Date: 2 August 2022

Application by Medworth CHP Limited for an Order Granting Development Consent for the Medworth Energy from Waste Combined Heat and Power Facility

Advice following issue of decision to accept the application for examination

LAND PLAN SHEET 1 OF 17

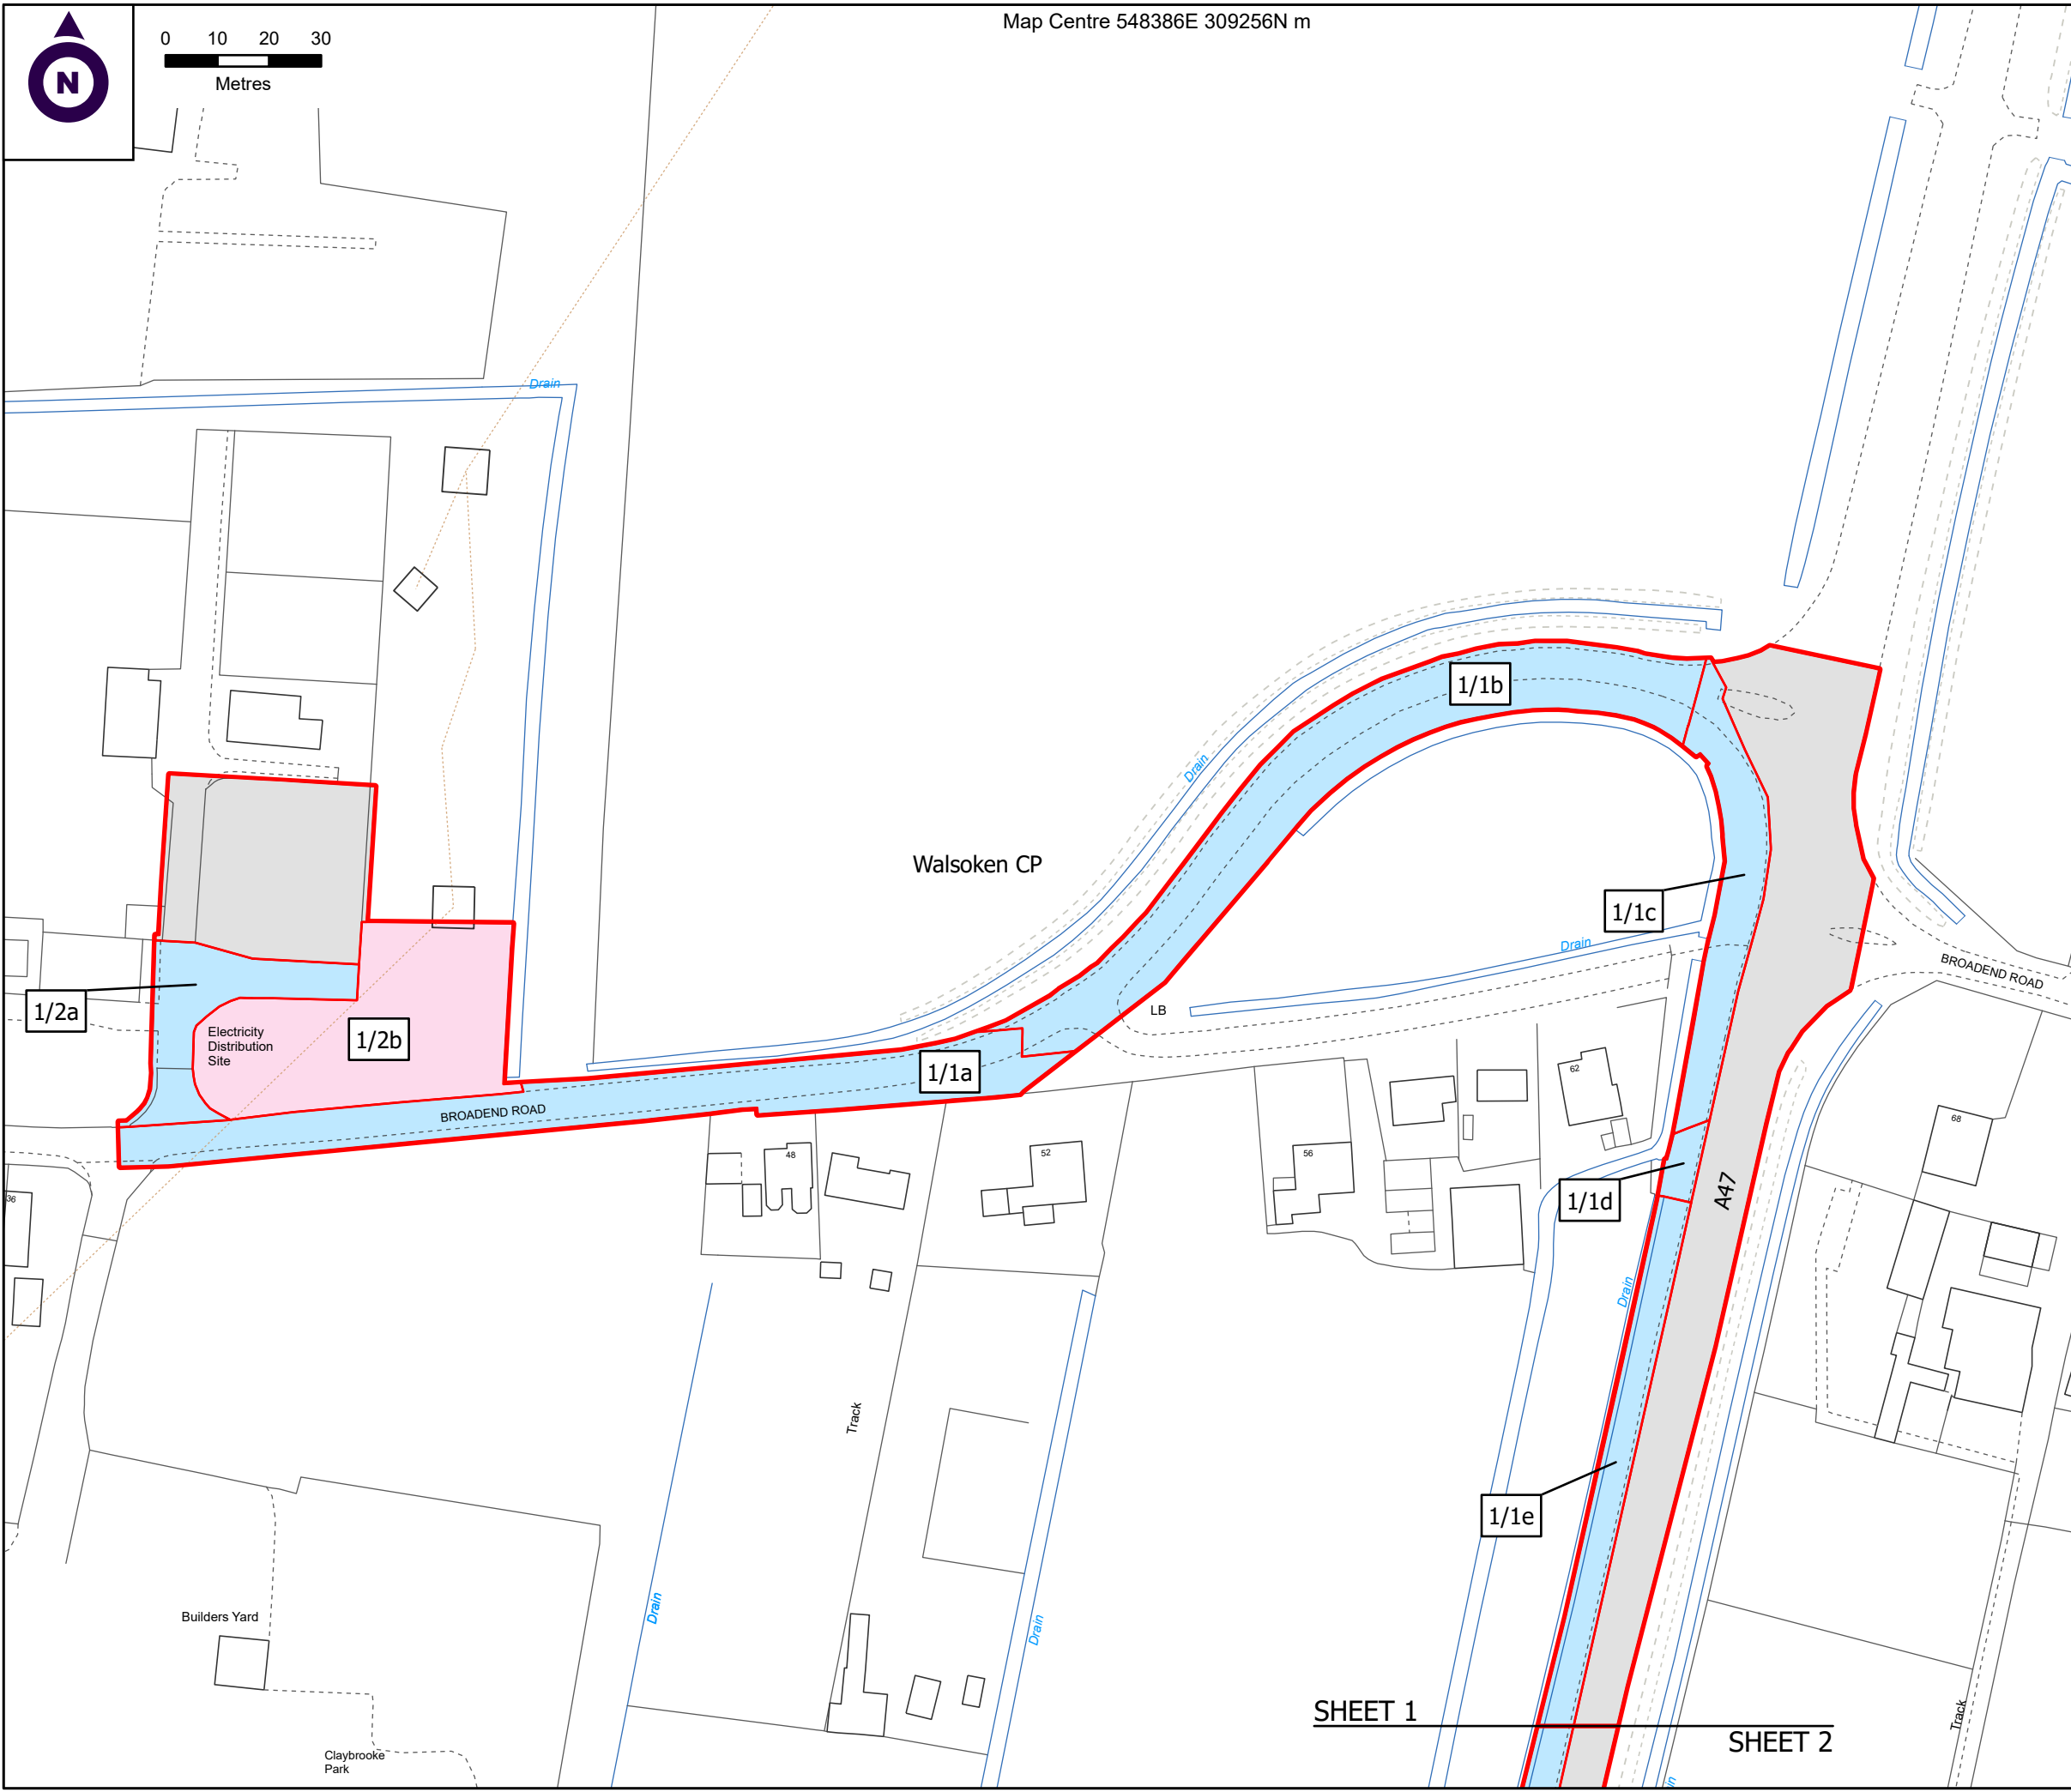
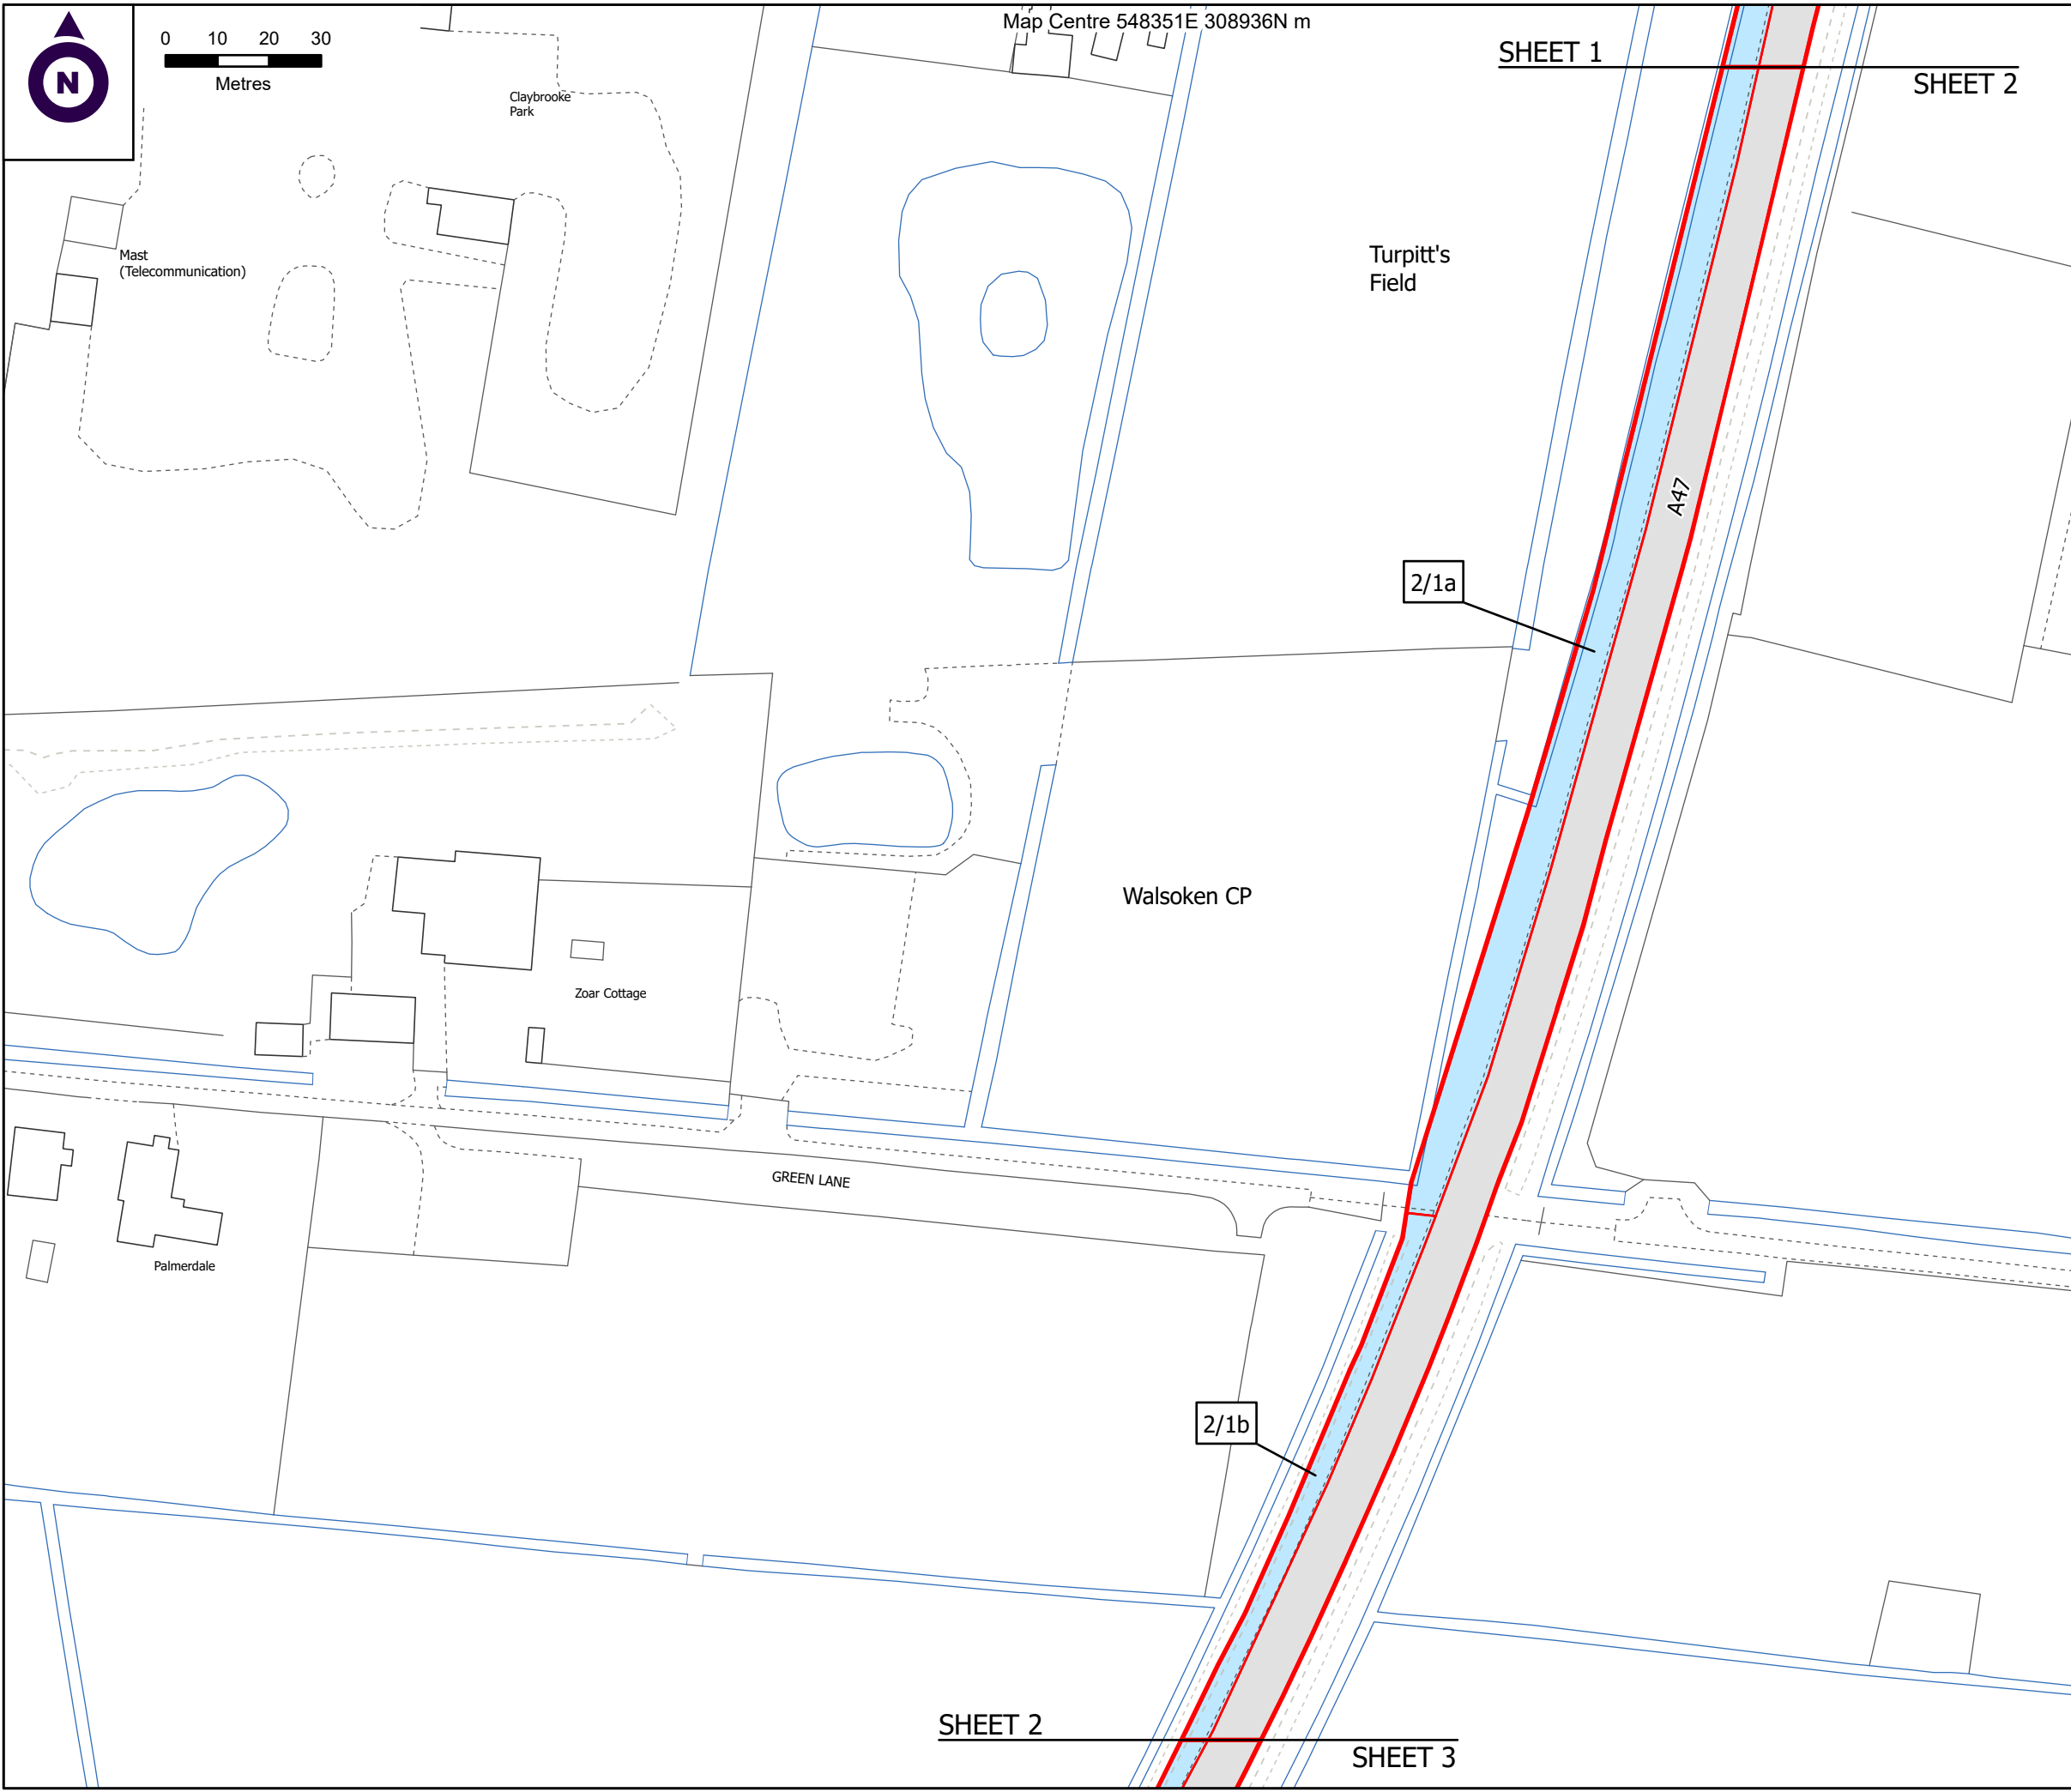
Due to the nature and extent of land affected by the proposal, the **Land Plans (Doc 2.2)** include several plots of land that span more than one sheet. According to the key, each plot must be demarked by a red line. However, for plots that span more than one sheet, this red line, necessary to define the beginning and/or end of a specific plot, is not clearly visible.

In order to enable more meaningful and relevant comments to be made on the application documents, it is suggested that any changes to the **Land Plans (Doc 2.2)** and the **Access**
